Item No. **Report of the Head of Planning, Transportation and Regeneration**

Address LAND ADJ. TO 33 HAZELWOOD DRIVE PINNER

Development: Erection of a single storey 2 bed house with associated parking and amenity space

LBH Ref Nos: **6342/APP/2020/1947**

Title			
Proposed Sections A-A and B-B			
Proj N°	Drawn by	Checked by	Scale
108	TB	TB	1:100
Date	Rev N°	Signed	
29/04/20		TB	
Number			
108-230

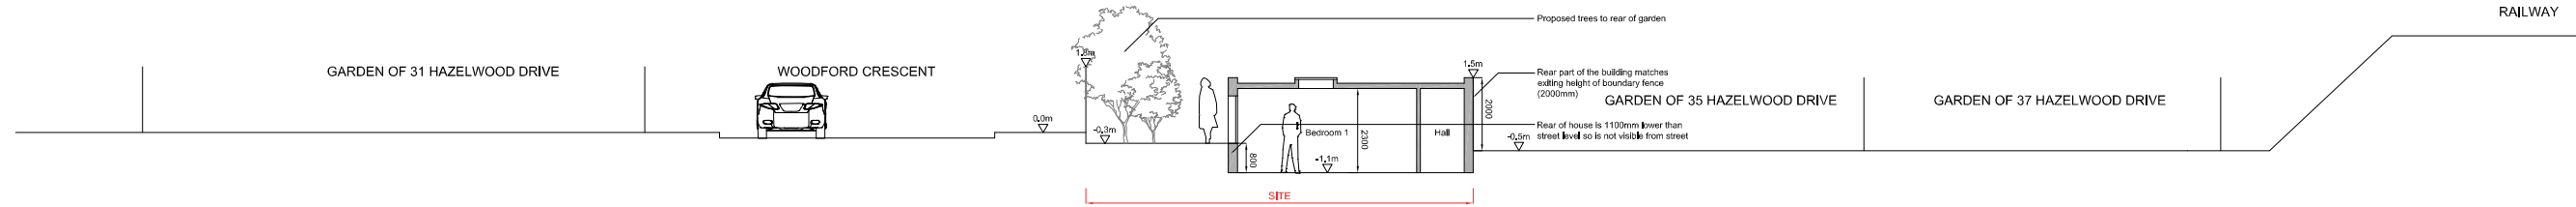
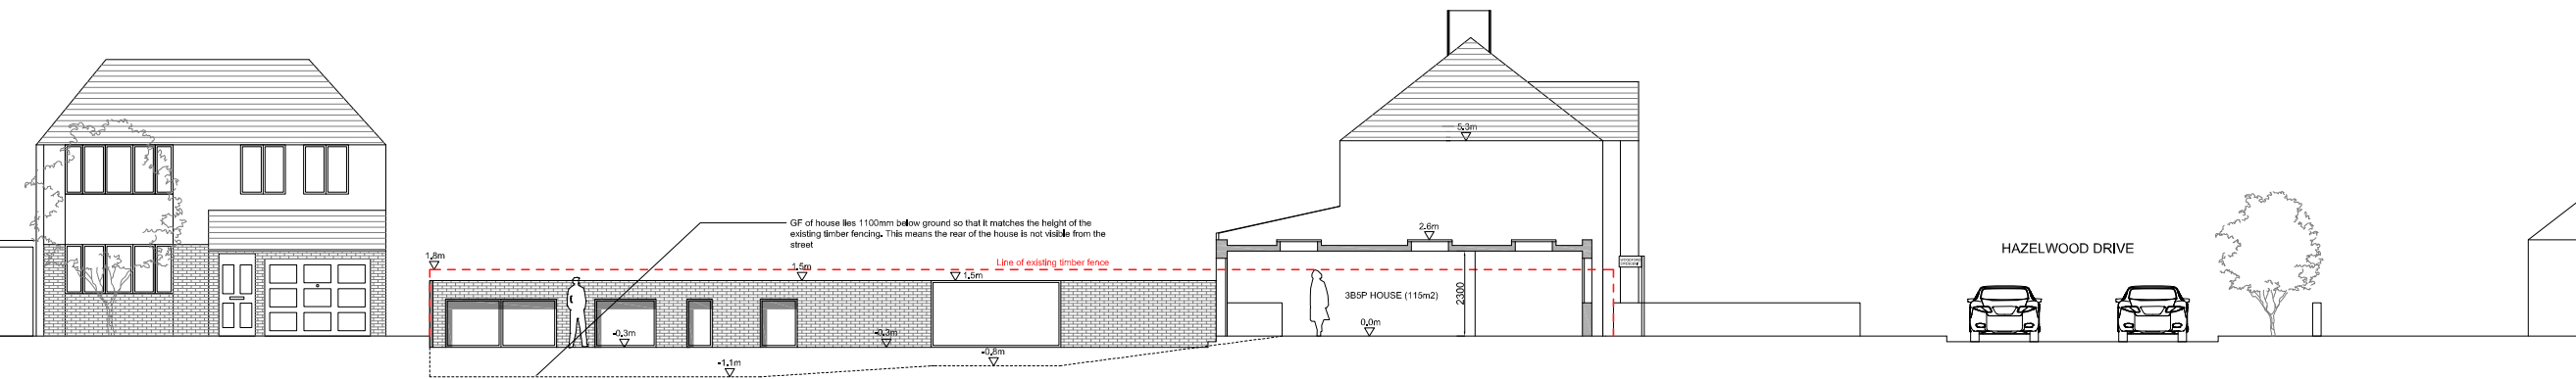
The rear element of the new dwelling would be built up to the rear garden boundary of the neighbouring property at 35 Hazelwood Drive however, as this element would be set below ground by 1 metre, the height above ground would not exceed 1.5 m and would therefore not be visible above a boundary fence of 1.8m. In addition there are no windows proposed in this abutting rear elevation. It would be set in from the boundary with the neighbouring property at 2 Woodford Crescent by 1.5m and would have a maximum height of 1.5m above ground level.

Although the proposed dwelling is of an attractive design in its own right, it would sit between 33 Hazelwood Drive and 2 Woodford Crescent both of which are two storey dwelling houses. The positioning of the bungalow between the two houses would appear somewhat out of keeping, given that street scene comprises rows of houses or bungalows which is a noticeable feature that contributes to the overall character and appearance of the two roads. That said, it is acknowledged that the development on this 'backland site' is more intimate in mass and scale and lower than frontage properties.

108-121

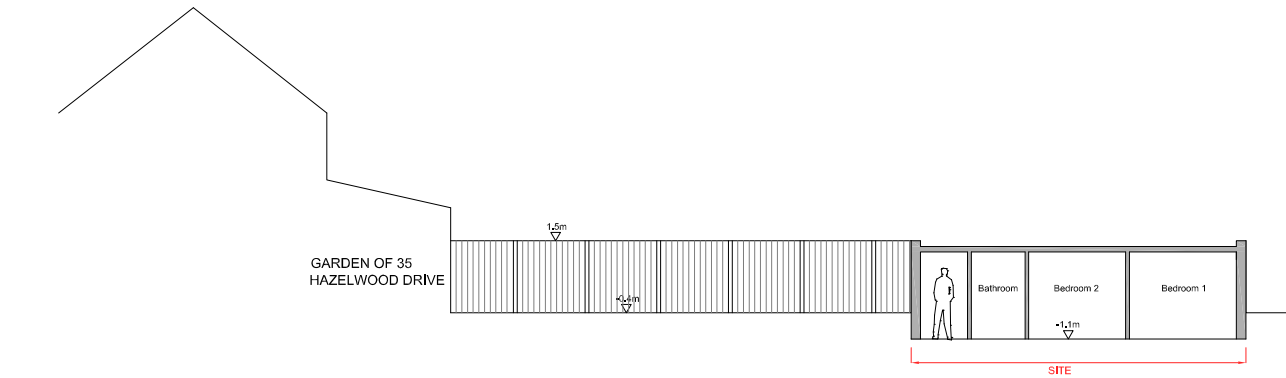
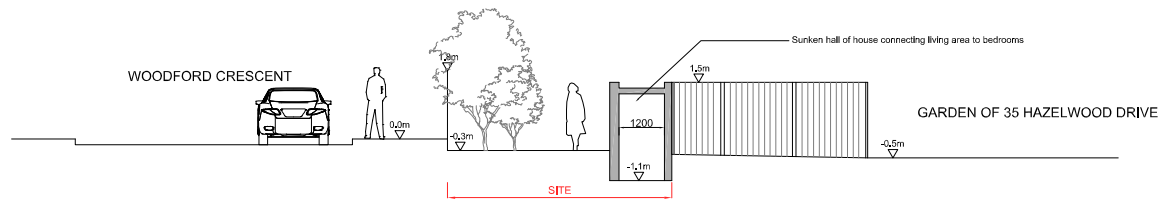
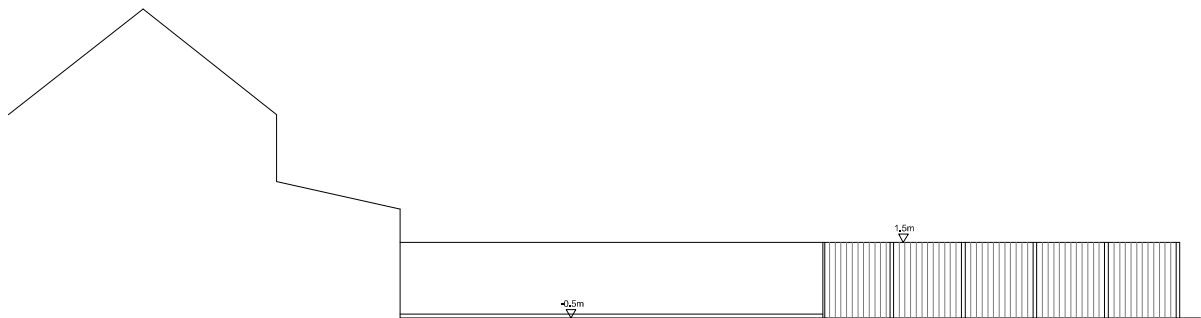
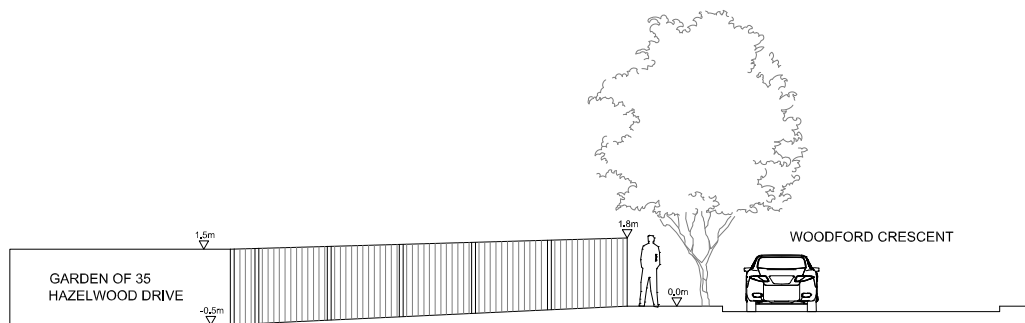
The proposed side extension element to the existing dwelling, by reason of its size, scale, bulk, width, and projection forward of the return building line along Woodford Crescent, in this open prominent position, would result in the closing of an important gap

The proposed side extension element to the existing dwelling, by reason of its size, scale, bulk and width would fail to harmonise with the architectural composition of the original dwelling and would be detrimental to the character, appearance and visual amenities of the street scene and the surrounding area. Therefore the proposal would be contrary to Policy BE1 of the Hillingdon Local Plan: Part One - Strategic Policies (November 2012) and Policies DMHB 11, DMHB 12 and DMHD 1 of the Hillingdon Local Plan: Part Two - Development Management Policies.
